RE: THOMAS STREET CAR PARK SITE CHATSWOOD MP09_0066 MODIFICATION 17

Willoughby City Council refers to Modification 17 of MP09_0066 to delete the louvres on Building 1 in the development nearing completion on the Thomas Street car park in Chatswood as follows:

BUILDING 1
ELEVATION - EAST

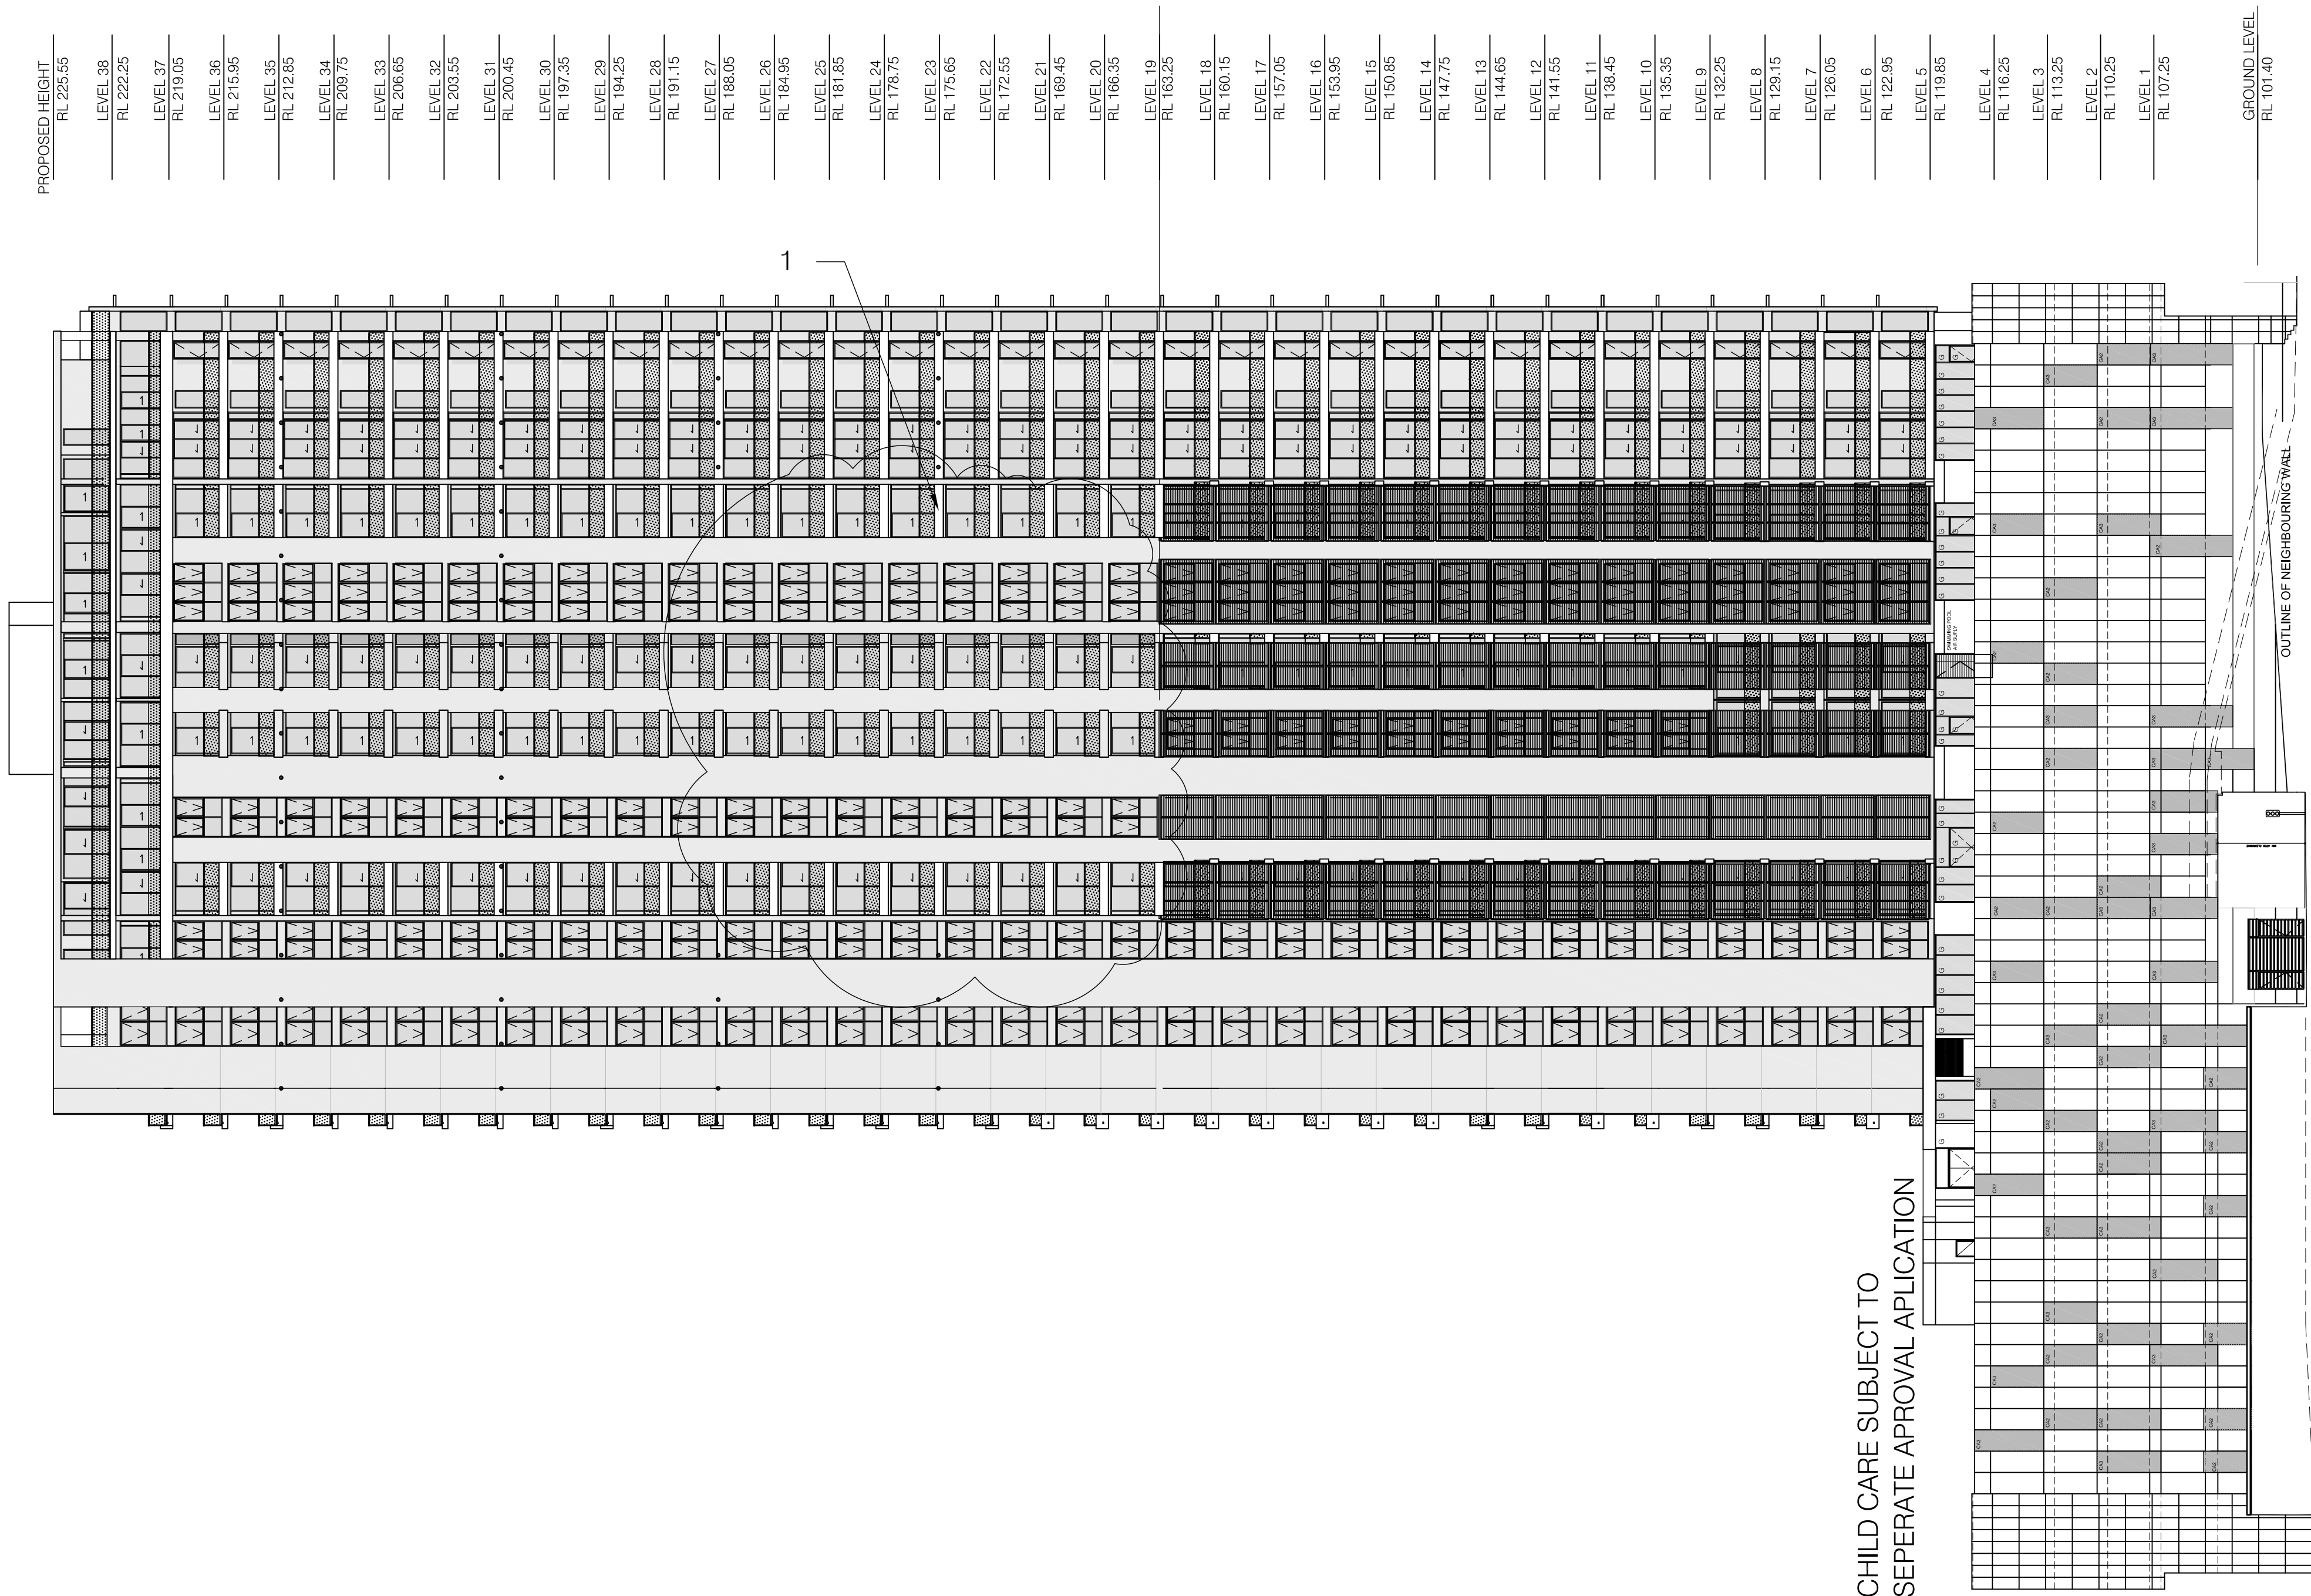
- Eastern Elevation on Levels 19 to 27
- Western Elevation on Levels 19 to 22

Council has no objection to the requested modification and considers this a matter for the Department to determine. Architecturally the external appearance of the building is considered will be improved by the removal of the louvres.
